**REQUEST**

Current Zoning: B-1(CD) (general business, conditional)  
Proposed Zoning: O-1(CD) (office, conditional)

Approximately 1.04 acres located at the northwest intersection of Carmel Road and Little Avenue, north of Pineville-Matthews Road, and east of Johnston Road.

The petition proposes redevelopment of the parcel with a new ~~17,200~~ 20,000 sq ft, 2 story building allowing all uses permitted in the O-1 zoning district in south Charlotte, just north of the Carmel Commons shopping center.

Conceptual Rezoning Plan

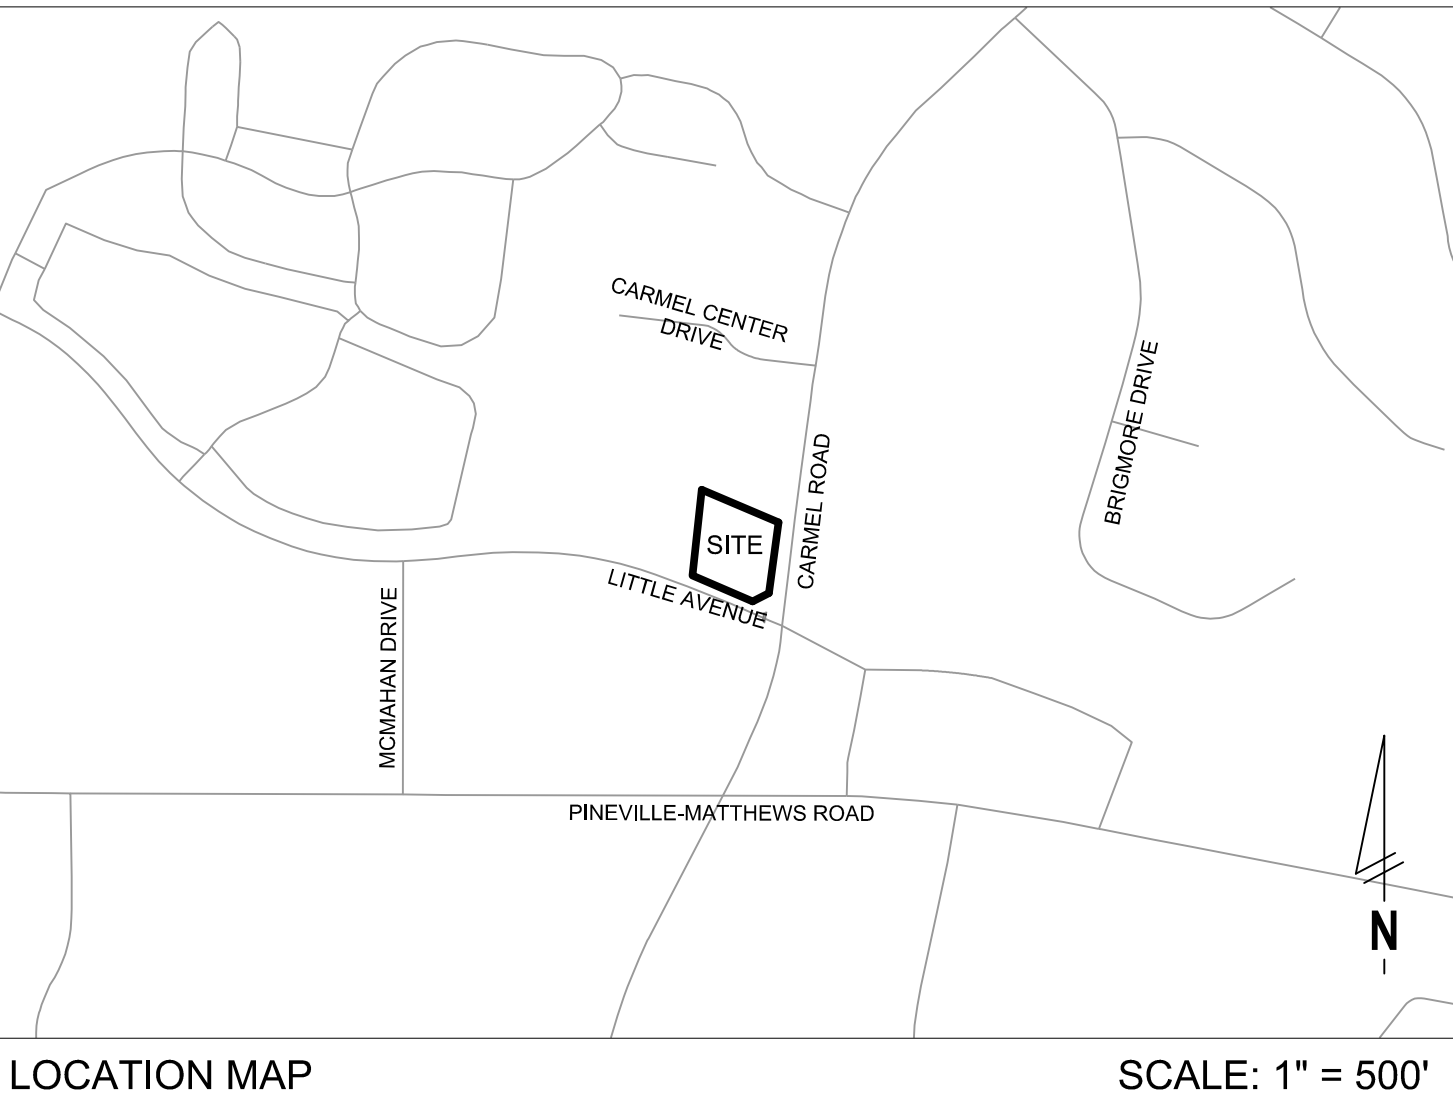
1. Incorporate architectural design standards as provided by Urban Design staff. **Addressed**
  - ~~Facades fronting streets shall include a combination of windows and operable doors for a minimum of 60% of each frontage elevation transparent glass between 2' and 10' on the first floor. Up to 20% of this requirement may be comprised of display windows. These display windows must maintain a minimum of 3'-0" clear depth between window and rear wall. Windows within this zone shall not be screened by film, decals, and other opaque material, glazing finishes or window treatments. The maximum sill height for required transparency shall not exceed 4'-0" above adjacent street sidewalk.~~

3. Add a note that no parking and maneuvering will be located between the building and street. **Addressed**

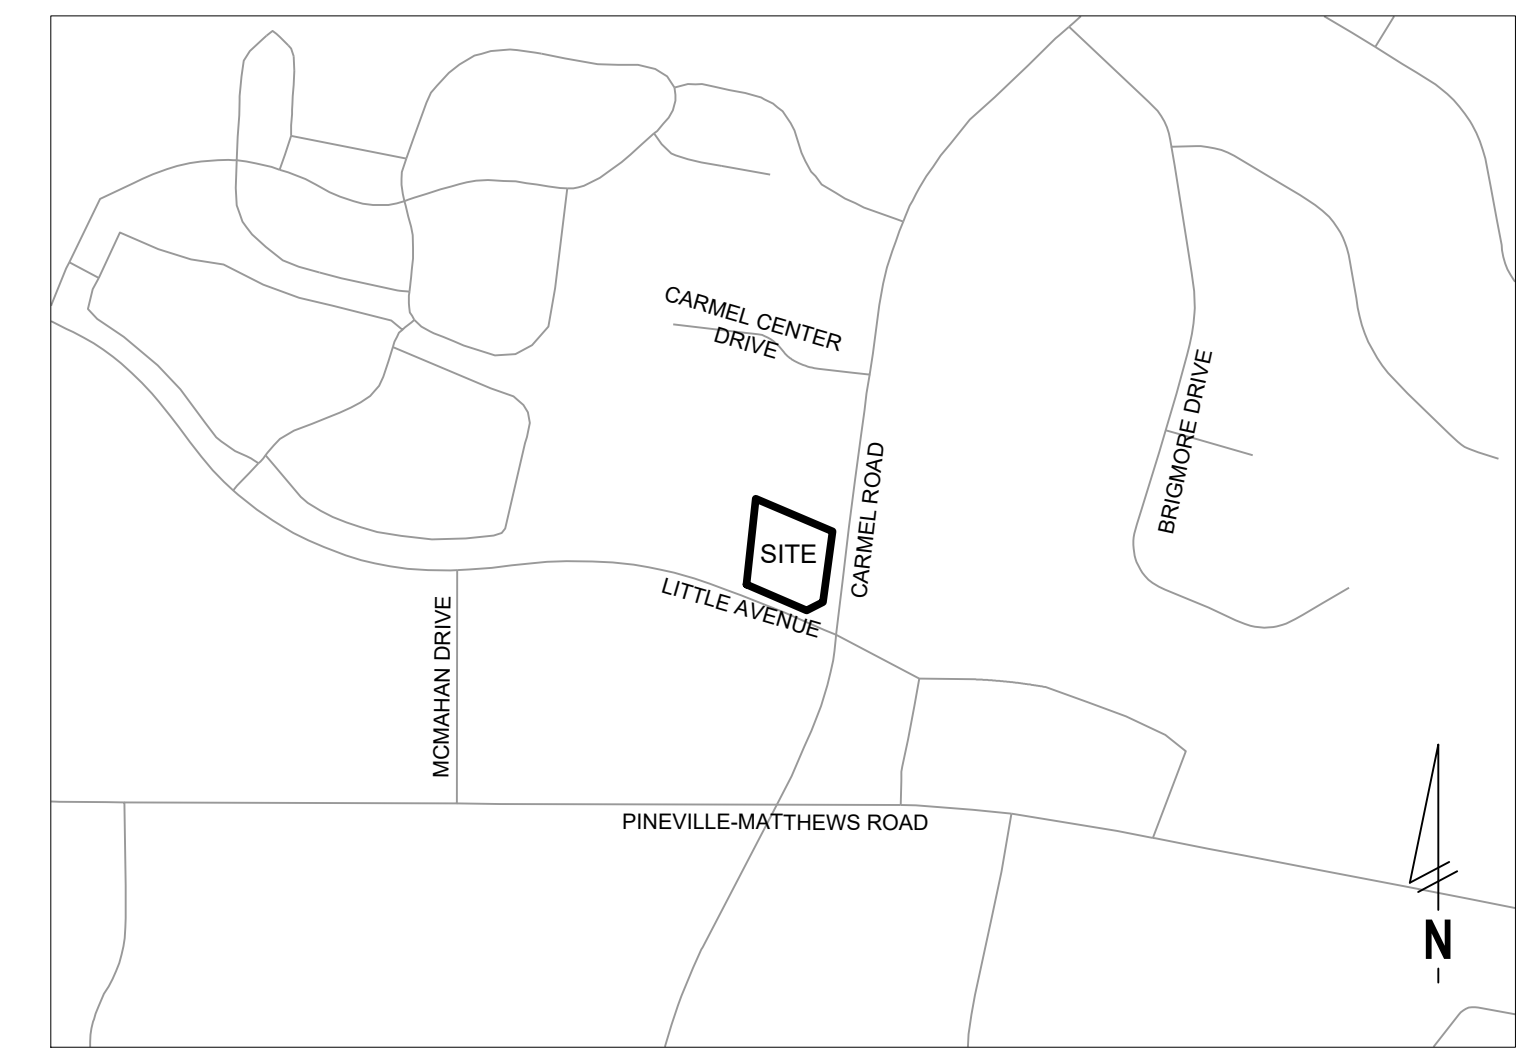
- ~~Multi-story buildings should have a minimum of 20% transparency on all upper stories.~~
2. Clarify if parking will be present under the building below grade or podium. If podium, the building should present ground floor active use along the public street fronts. **Addressed**

4. Adjust the site plan to show the back of curb and gutter along Carmel Rd at 33ft from the centerline to accommodate the Charlotte Streets Map with a roadway typical section of CLDSM 11.09 Major Thoroughfare. (Site plan currently shows 32 ft from centerline.) **Addressed**

5. Remove layers showing existing development or move the existing development information to a separate sheet. **Addressed**
6. Label and dimension the 12 ft multi-use path and 8 ft planting strip shown along Carmel Rd. and label and dimension the existing planting strip and sidewalk along Little Ave. **Addressed**
7. Add a note committing to the construction of the 8 ft planting strip and 12 ft multiuse path. **Addressed**
8. Add a note committing to the provision of the 14 ft Class C buffer that is shown on the site plan. **Addressed**

9. Label and dimension the curb and gutter from the centerline of each road on the site plan. **Addressed**
